Your Ref: AL/66/15/DOC

Town & Country Planning Act 1990 (as amended)
Town and Country Planning (Development Management Procedure) (England) Order 2015
Application for approval of matters reserved by condition imposed under AL/11/15/L relating to
conditions 3, 4 & 5 for details of construction & materials of external joinery & new glass roof &
details of internal wall insulation.
Meadow Cottage Hook Lane, Aldingbourne,

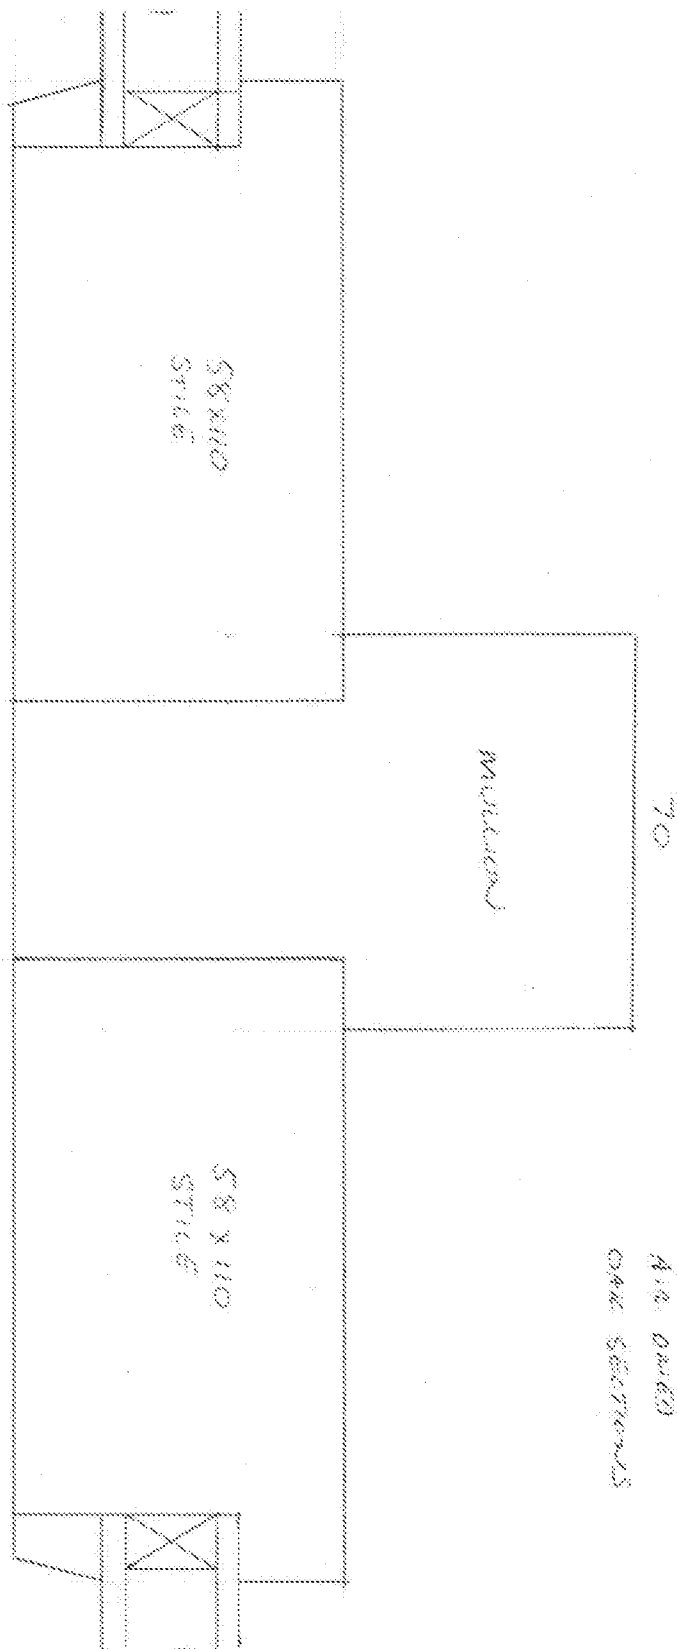
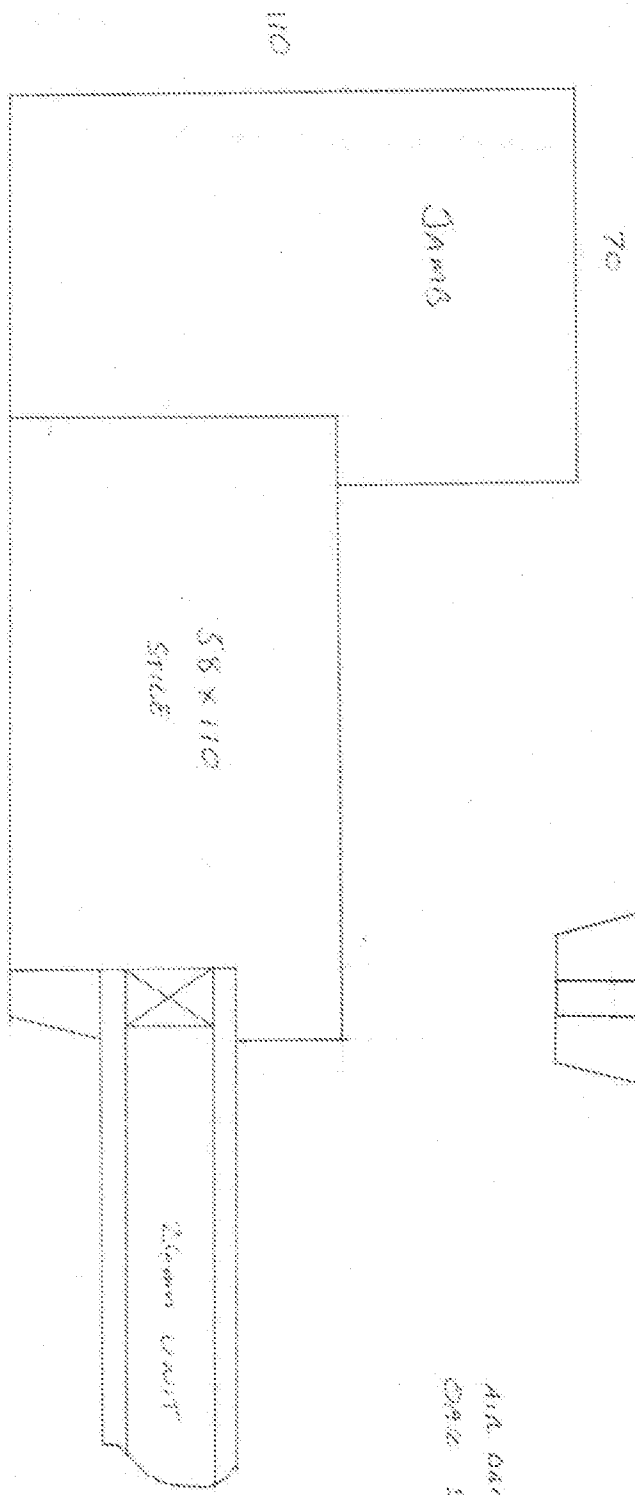
The details submitted in respect of the new external joinery (windows & doors) namely the door elevations, new garage room window elevations, frame detail drawings and the written agreement to the use of 14-16mm glazing for the large doors at the rear & 11-12mm glazing for the new windows are all considered to be satisfactory and satisfy the requirements of the condition.
